Application for a Non-Material Amendment Following a Grant of Planning Permission

Sheridan Road Shops - Crosslinks
 Proposed Elevations (Revised)

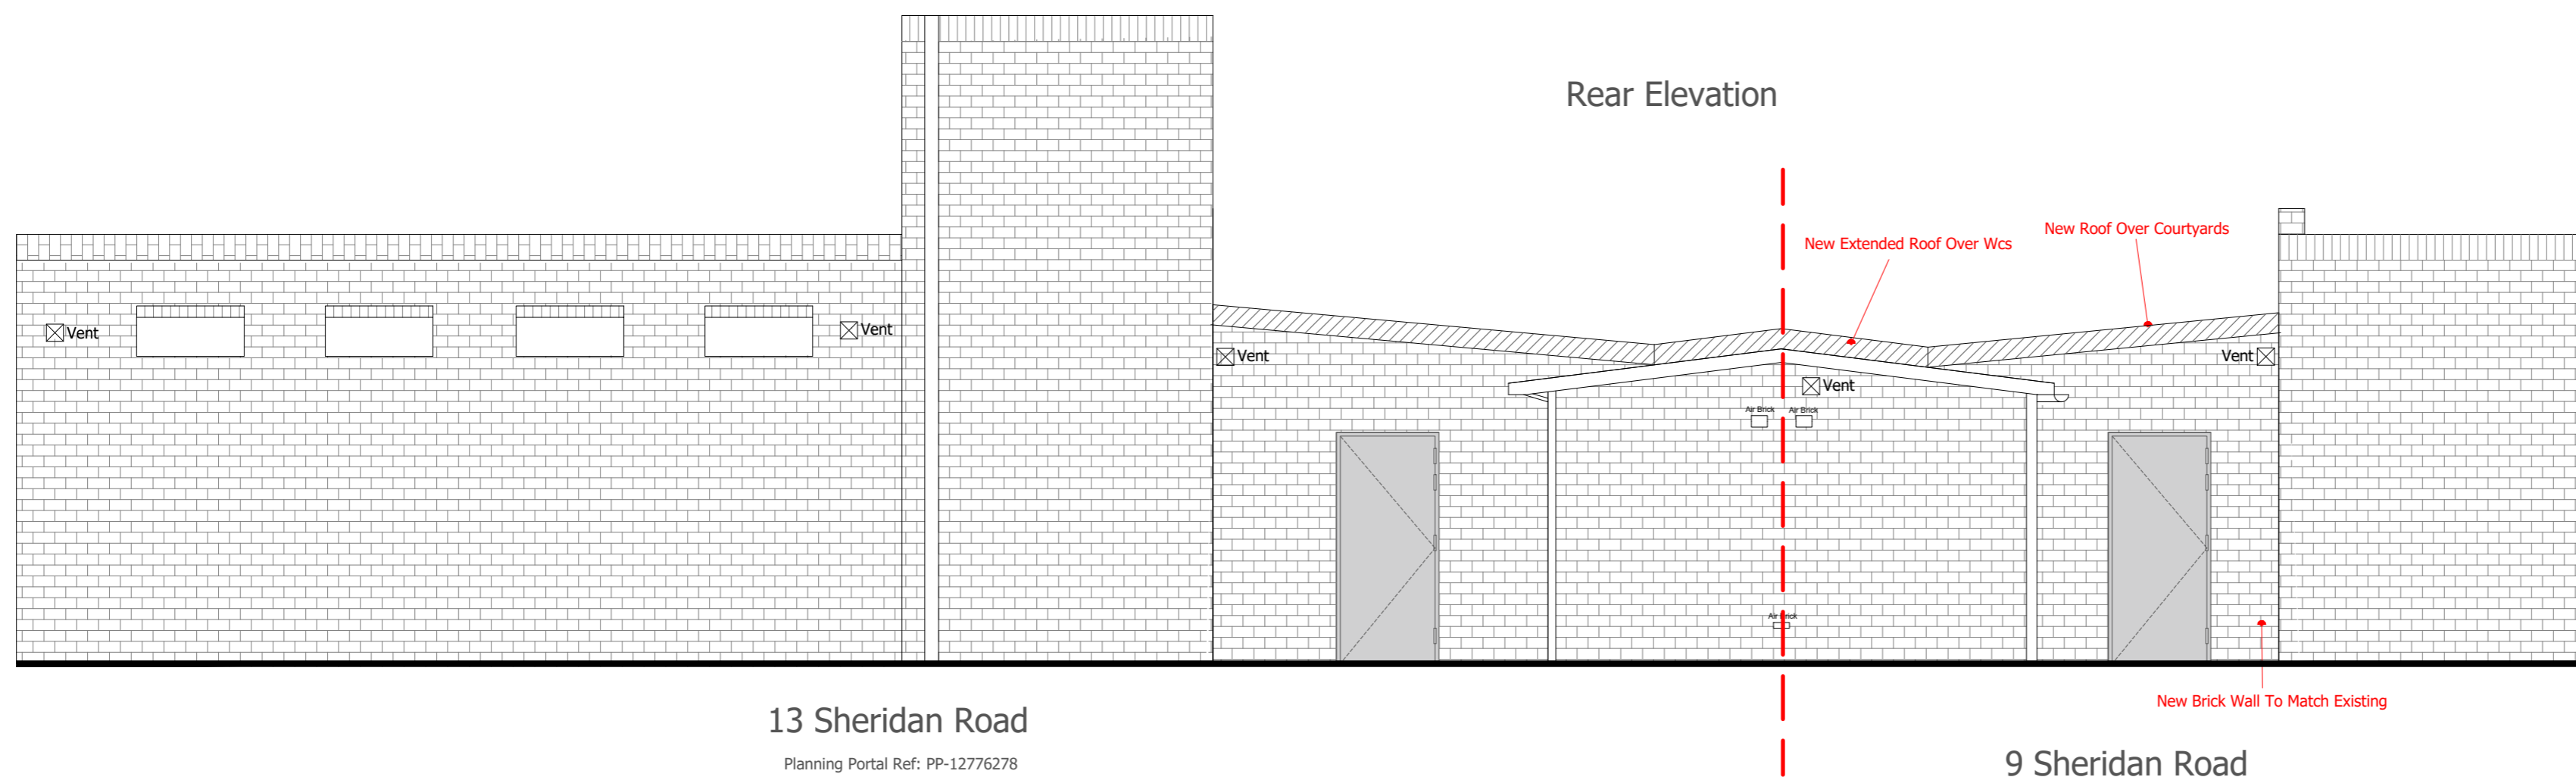
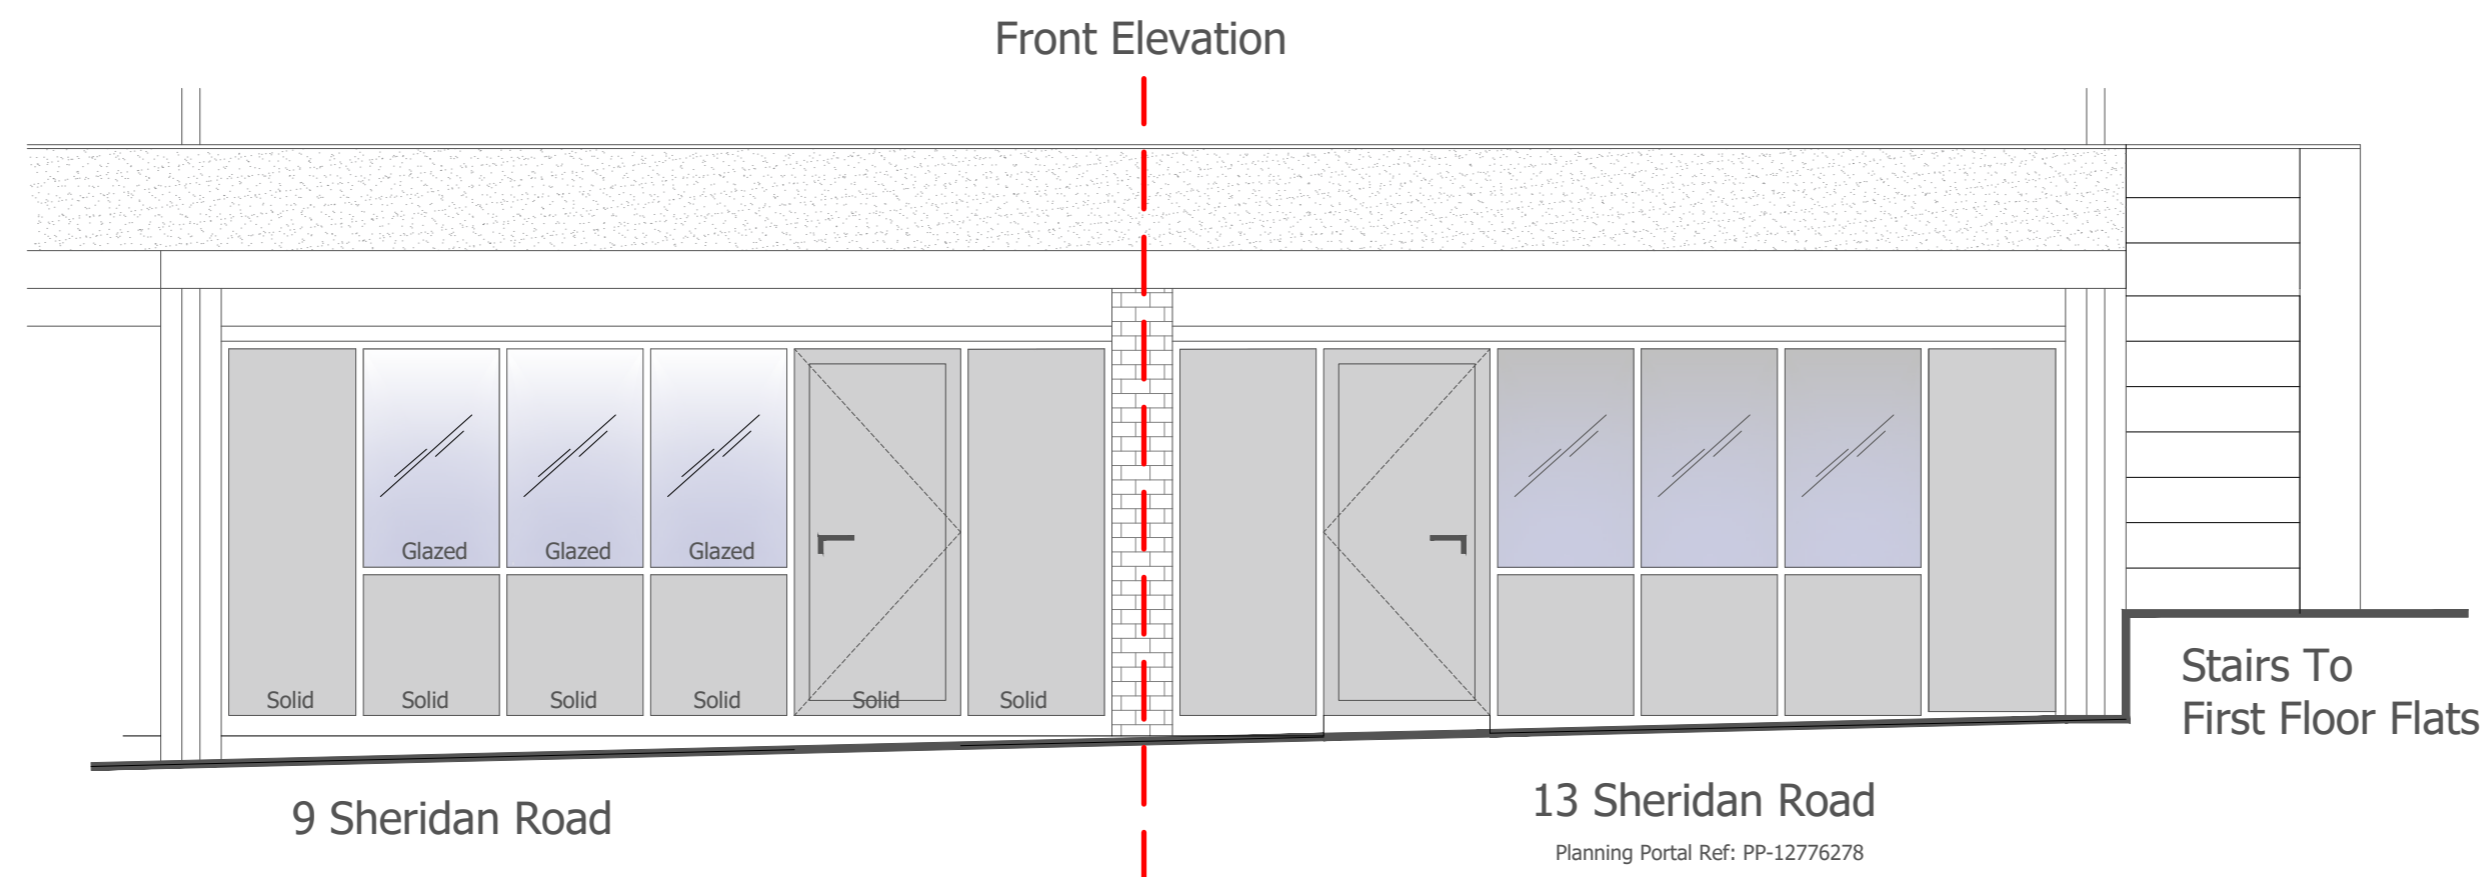
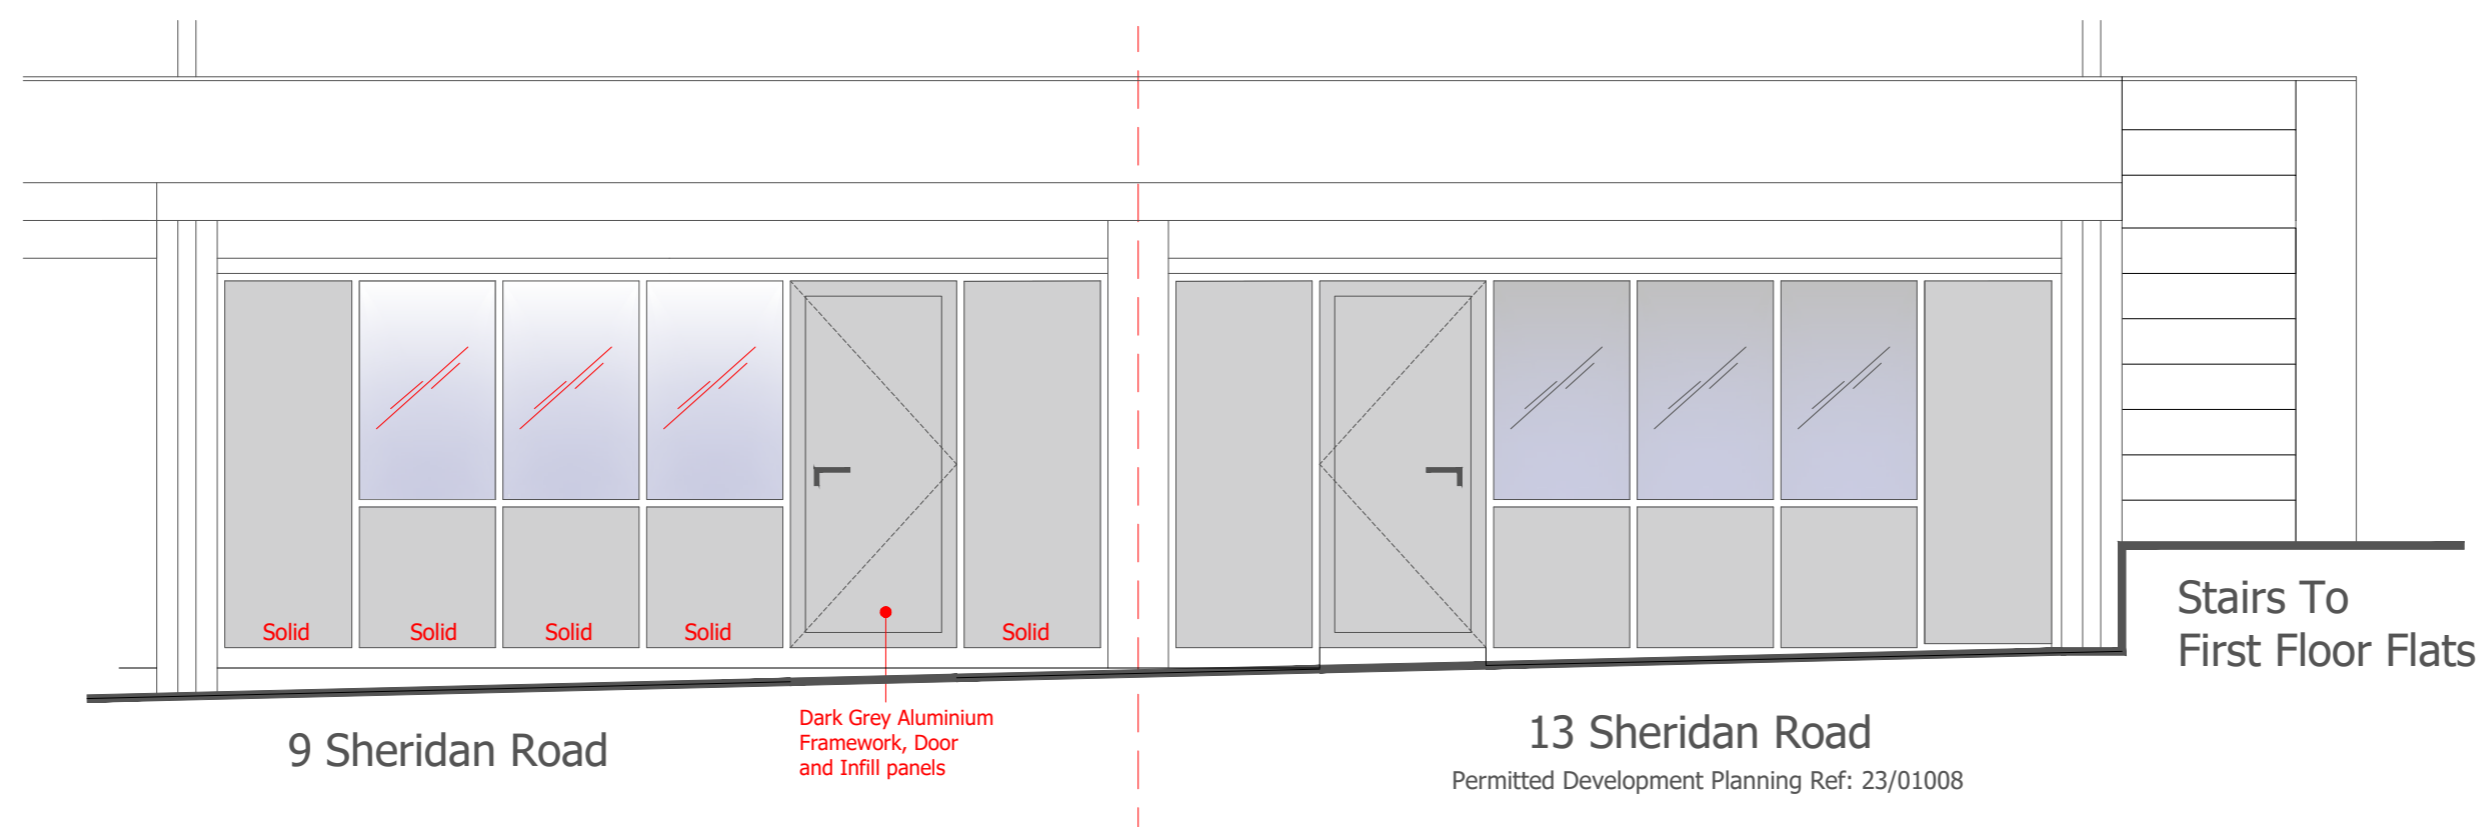
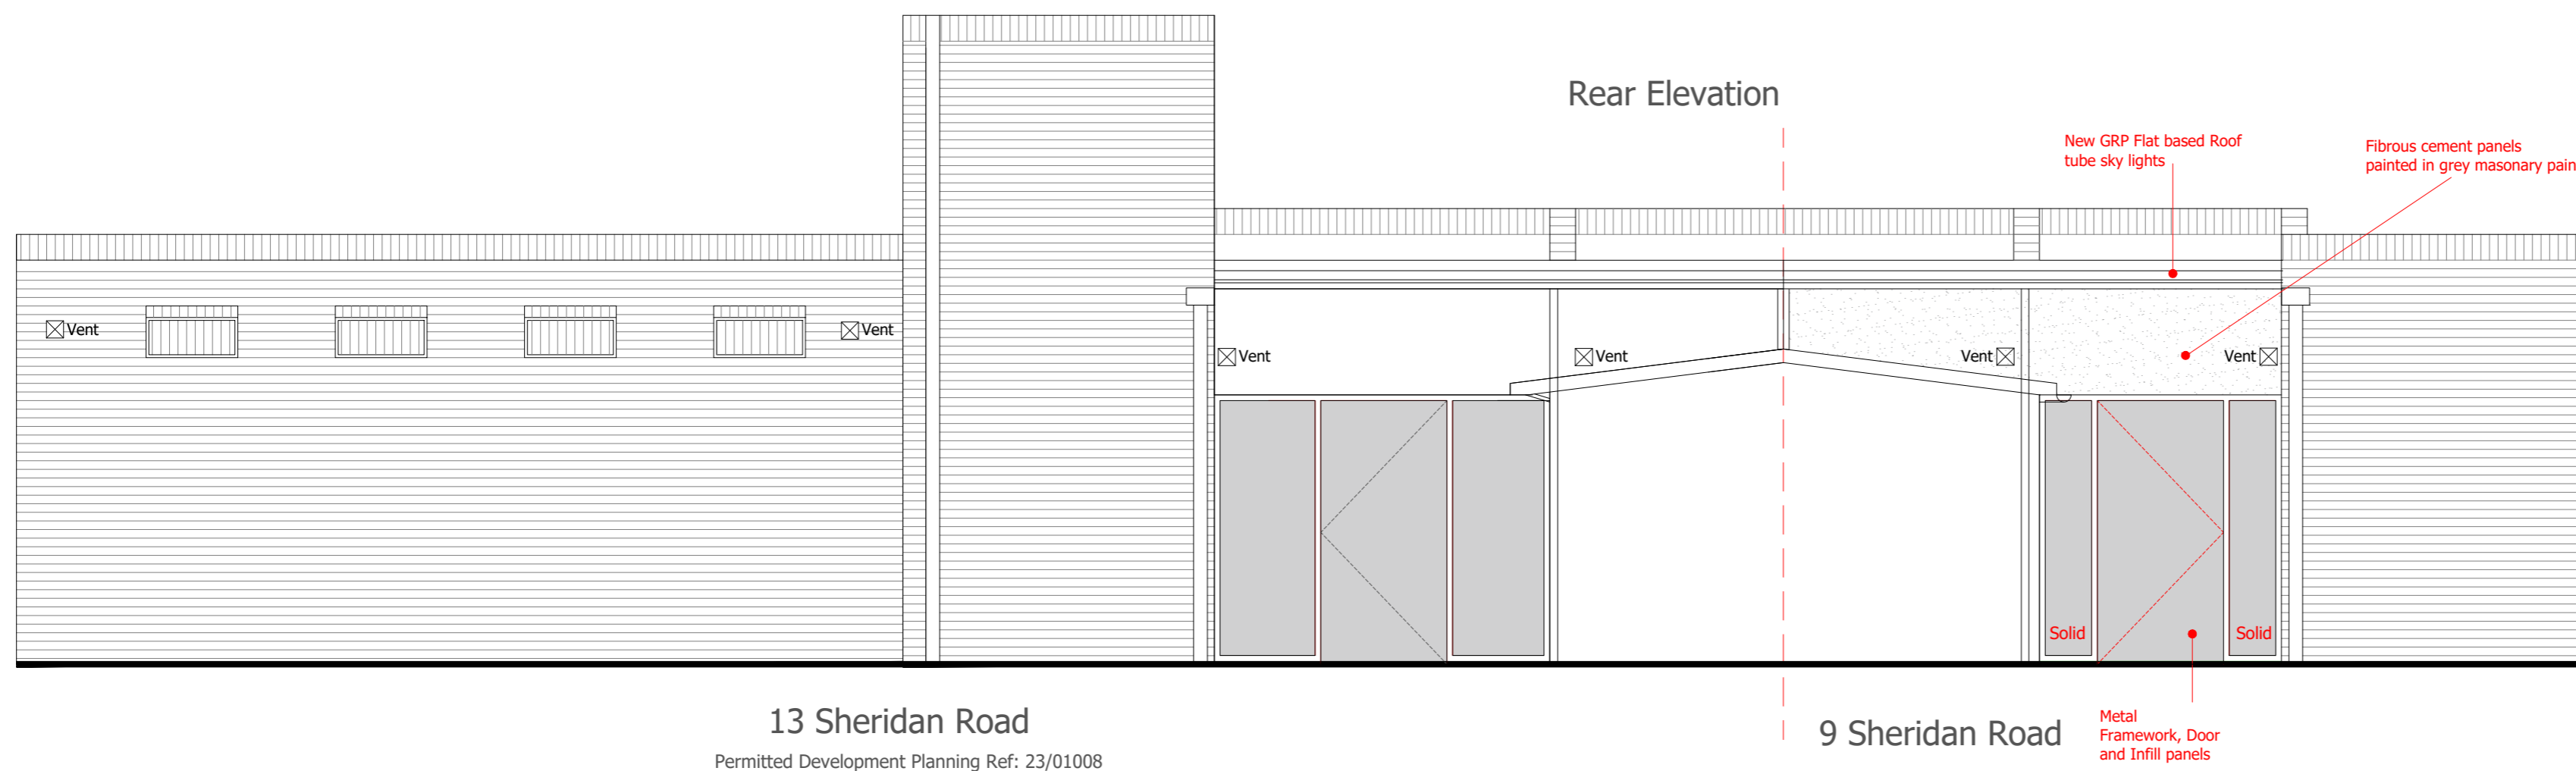
- alterations to required drainage.
- improved rigidity of roof structure.
- how the roof will connect with neighbouring property (see application PP-12776278)

Site Plan
Original Proposal for Courtyard Roof - Elevations To Front, Rear and South East - 9 Sheridan Road
Original Courtyard Roof Detail - 9 Sheridan Road
Proposed Amendments for Courtyard Roof- Elevations To Front, Rear and South East - 9 Sheridan Road
Proposed Roof Detail to Courtyards - 9 Sheridan Road
